From: Maria Tomalova <Maria.Tomalova@arun.gov.uk>
Sent: 19 February 2021 18:55
To: Planning.Responses <Planning.Responses@arun.gov.uk>
Subject: FW: AL/2/21/DOC Tyrone House

'The supporting statement includes plan demonstrating a car parking for the proposed dwelling; however this has not been scaled. The proposed plan demonstrates 4 parking spaces, 2 within the proposed garage and 2 on the driveway. At planning stage, the proposed garage did not meet the requirements for a double garage. It is not clear if the internal size of the garage has been enlarged to accord with the current WSCC standards for double garage (6x 6m). Nevertheless, the

With regards to materials, the approved elevations show greyish/bluish render in a combination with white and there are also some interesting details on eaves. Did your client changed a mind?

FIGURE 1 - PROPOSED PARKING

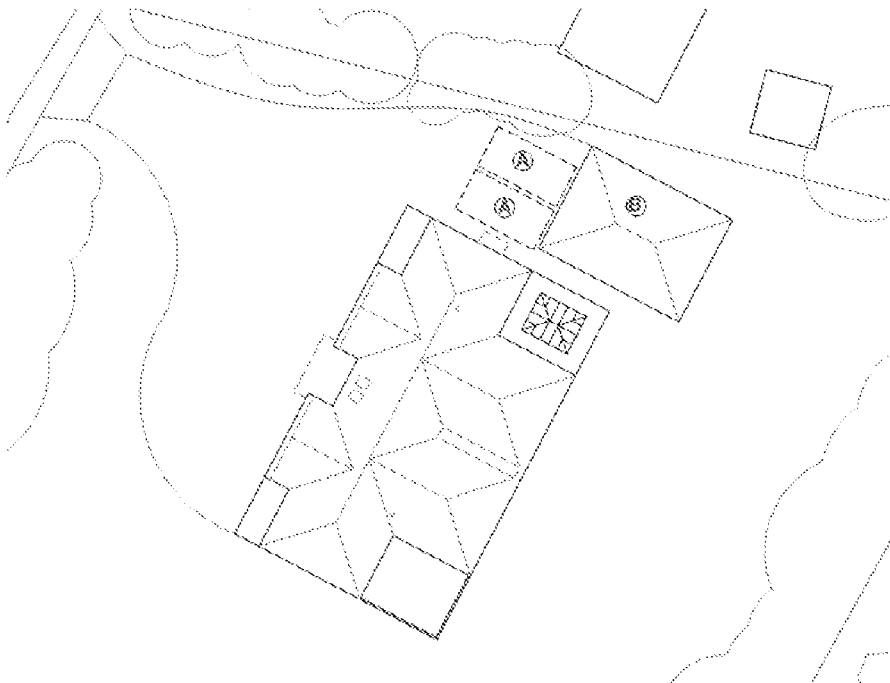
site appears of sufficient size to accommodate the required onsite parking provision of 3 spaces. The details submitted would be considered adequate to meet the requirement of condition 7.'

It looks generally OK, however if you can provide scaled plan it would be beneficial.

The garage is 6 x 6m internally – permitted drawing with dimensions added attached.
